Development Control
Ribble Valley Borough Council

Your ref: 22.0852
Our ref: D3.22.0852
Date: 4th January 2023

Address: Proposed new field access onto highway including creation of culvert

Proposal: Cragg House Farm Collins Lane Chipping

Project Details:
PROPOSED FIELD ENTRANCE

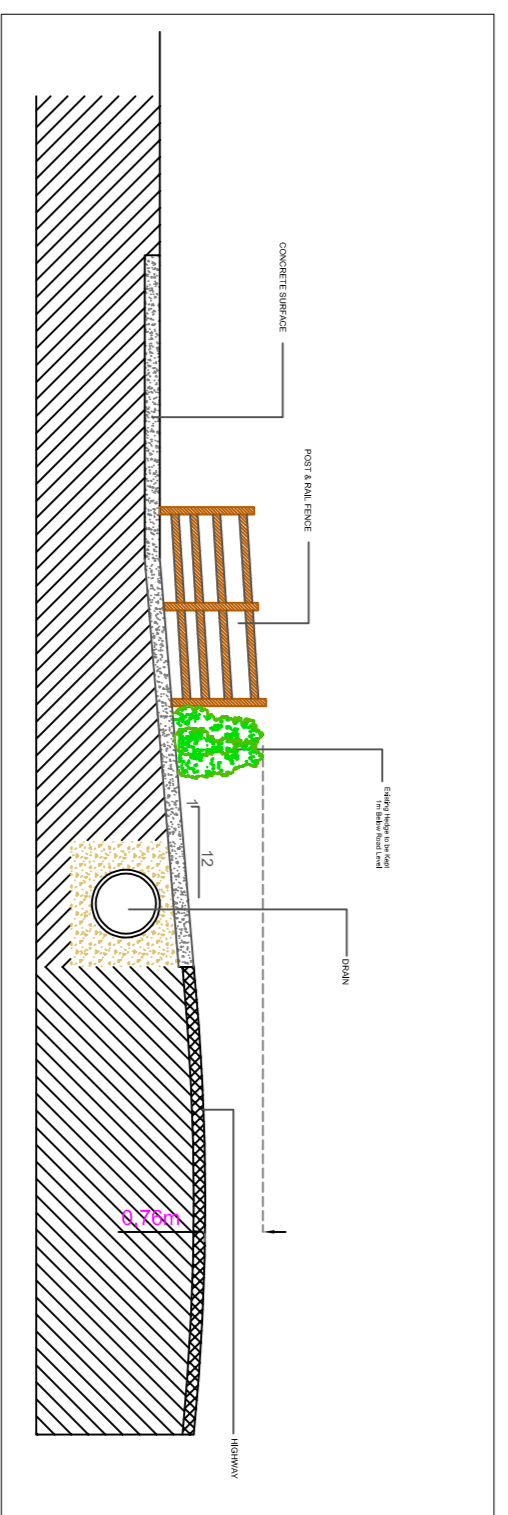
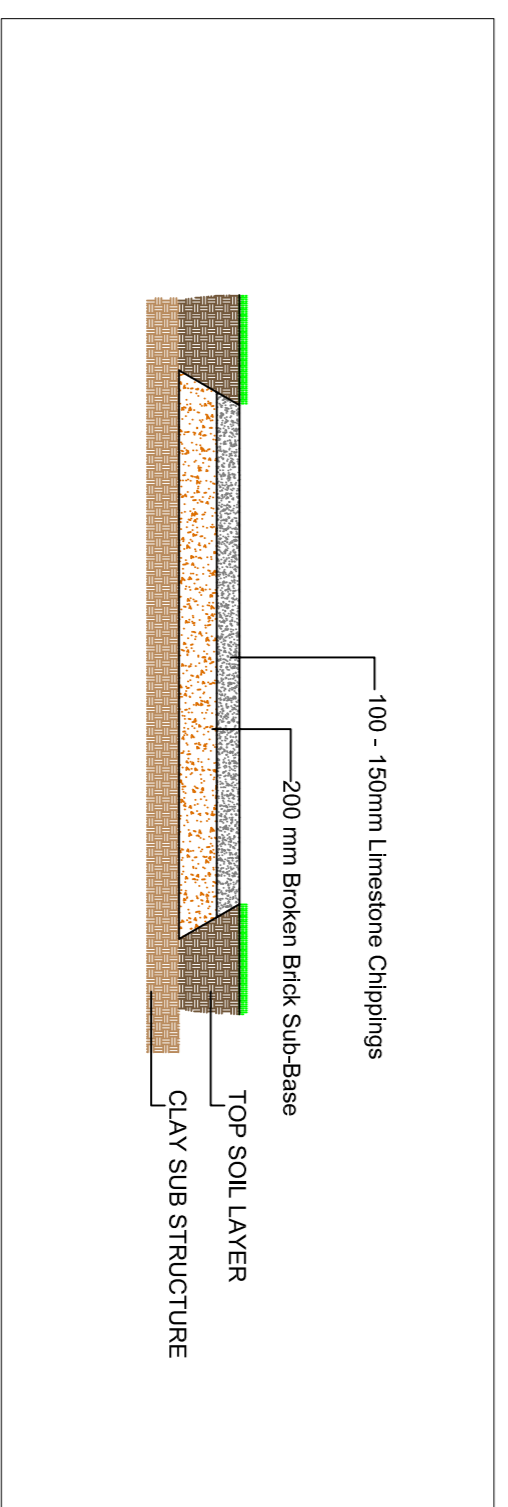
2. Any gates shall be set back by at least 12m from the edge of the highway and shall open inwards to the site.
3. Notwithstanding the provisions of the Town and Country Planning (General Permitted Development) Order 1995 there shall not at any time in connection with the development hereby permitted be erected or planted or allowed to remain upon the land hereinafter defined any building, wall, fence, hedge, tree, shrub or other device over 1m above road level. The visibility splay to be the subject of this condition shall be that land in front of a line drawn from a point 2.4 m measured along the centre line of the proposed road from the continuation of the nearer edge of the carriageway of Fiddler's Lane to points measured 215m to both sides along the nearer edge of the carriageway of Fiddler's Lane, from the centre line of the

PROPOSED VISIBILITY SPLAYS

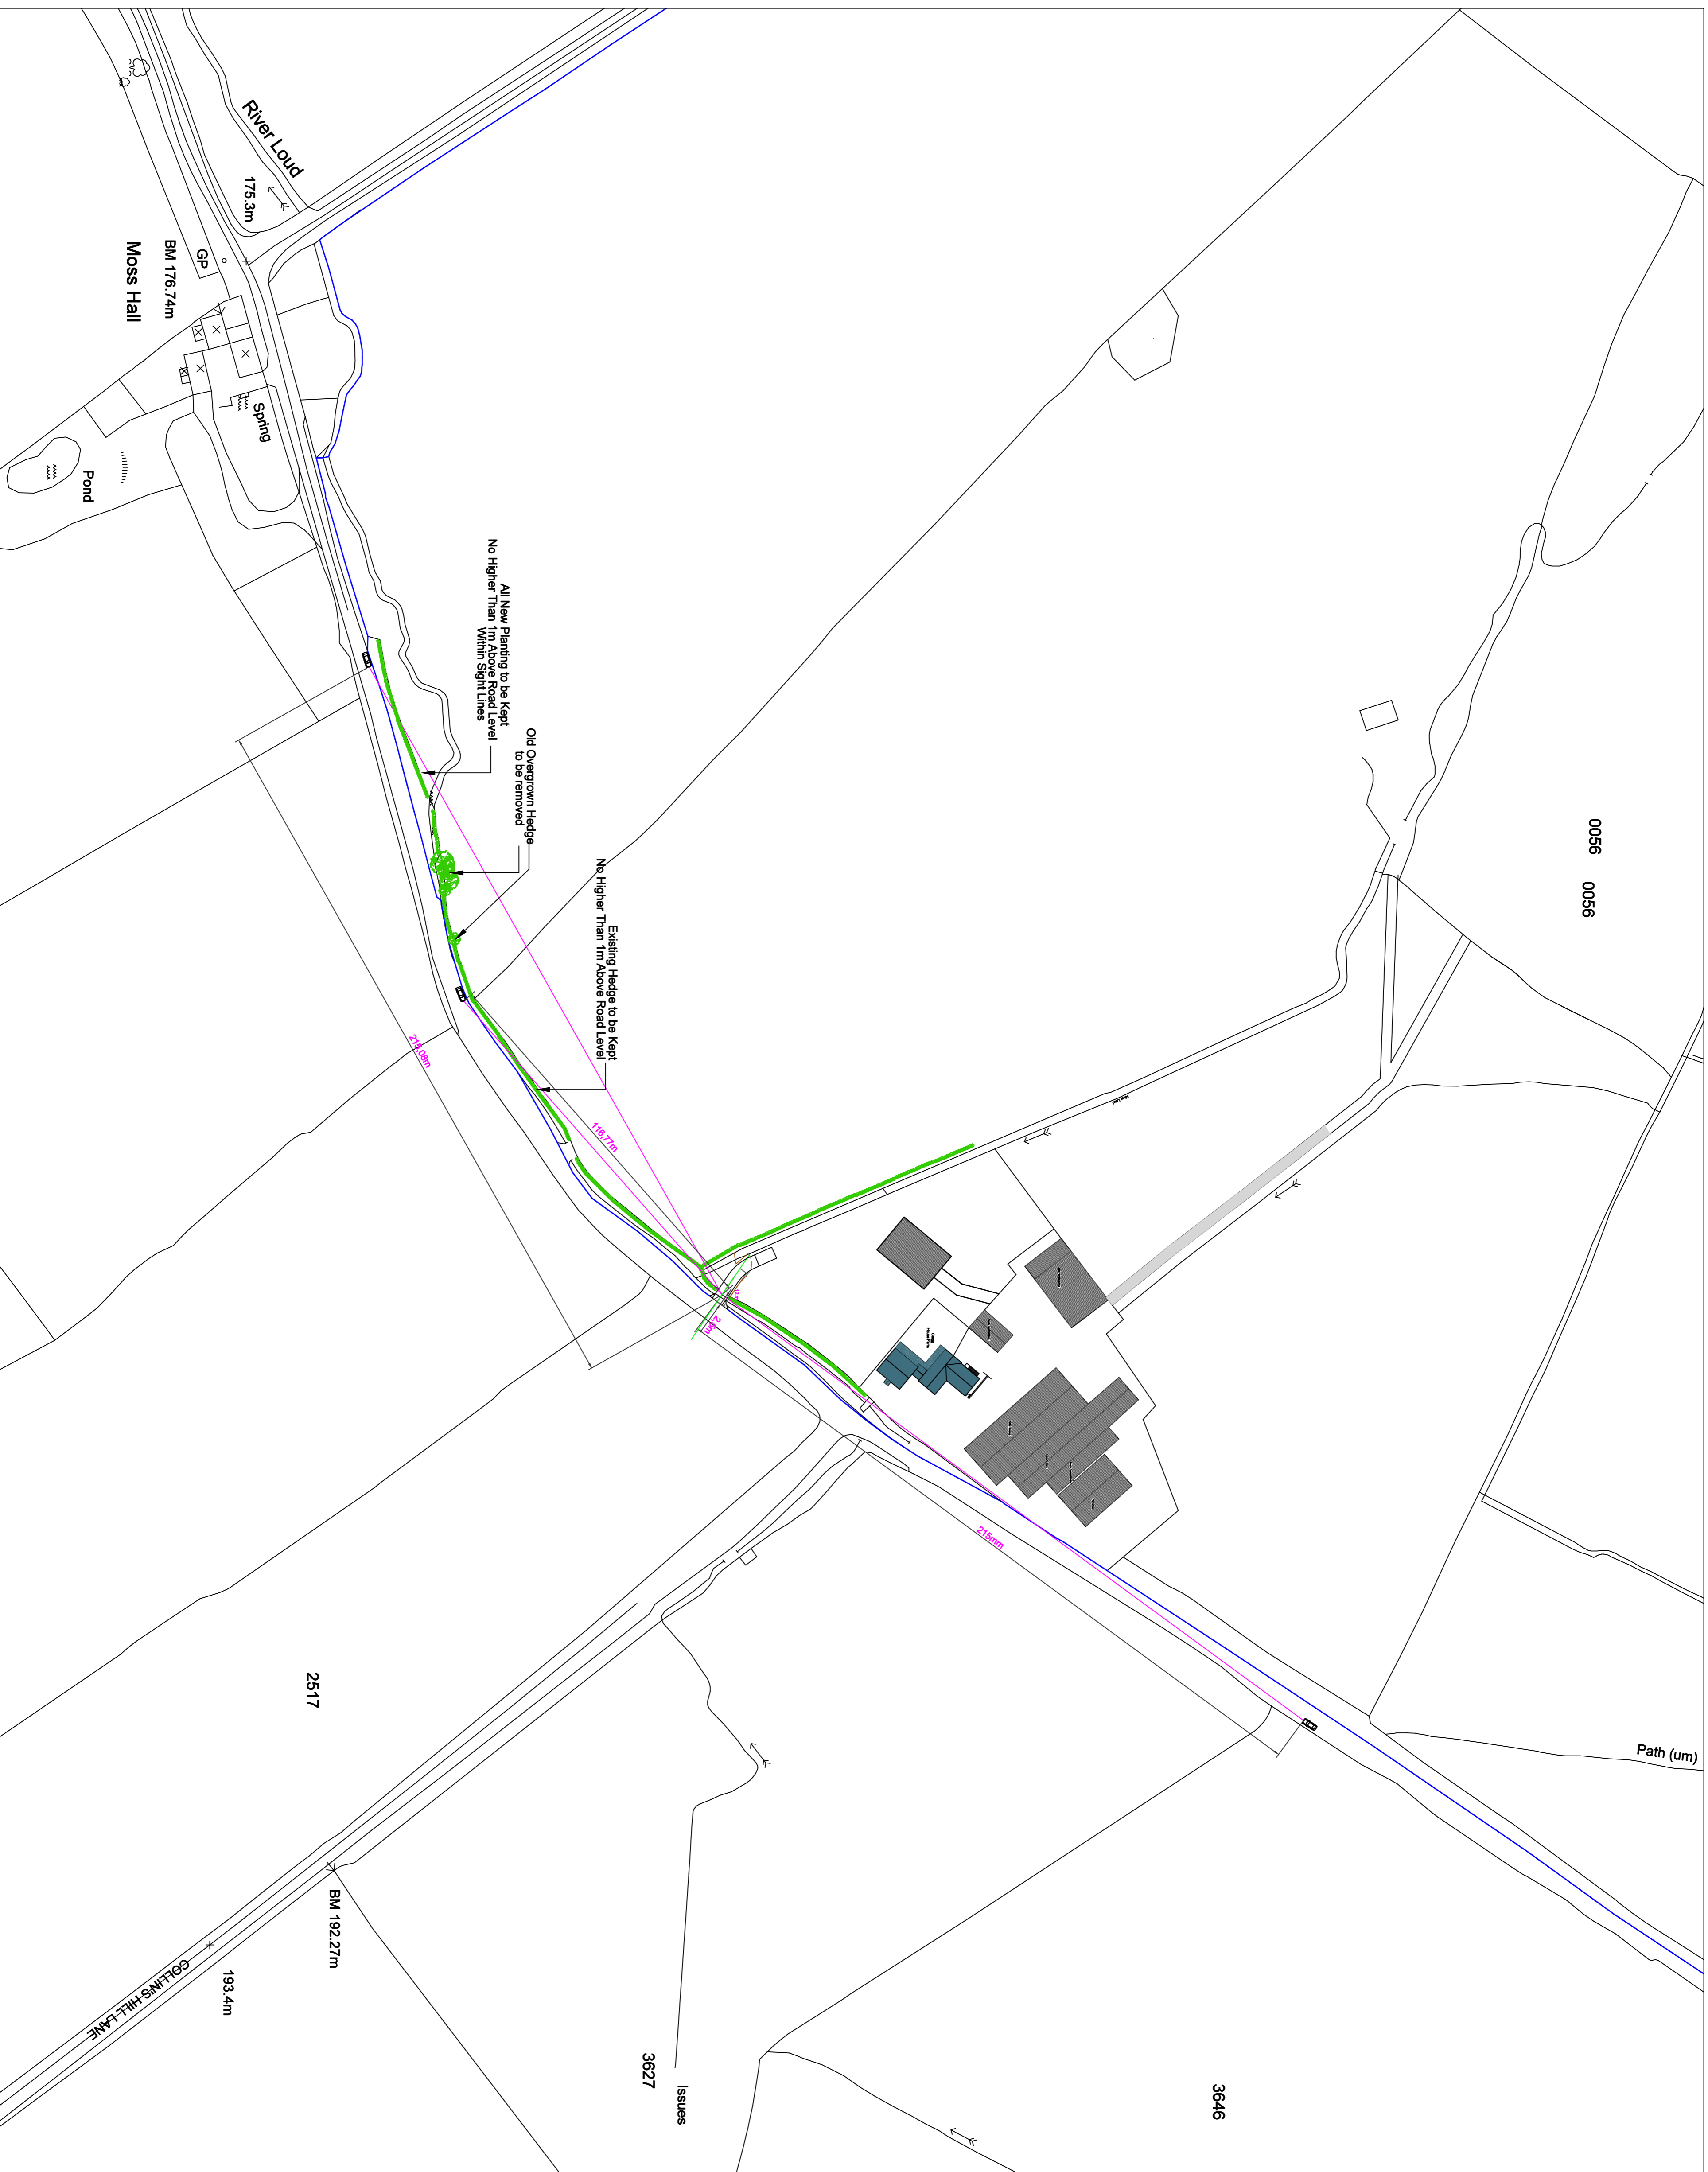
Fiddler's Lane is classified C566 and subject to the national speed limit. The visibility splay for a national speed limit is X2.4m by Y215m in both directions along Fiddler's Lane. The submitted visibility splay drawing demonstrates that the splays lie across land within the control of the applicant, but it would require significant sections of vegetation to be removed or maintained below 1m high in perpetuity.

access, in accordance with a scheme to be agreed by the Local Planning Authority in conjunction with the Highway Authority. Reason: To ensure adequate visibility at the street junction or site access.
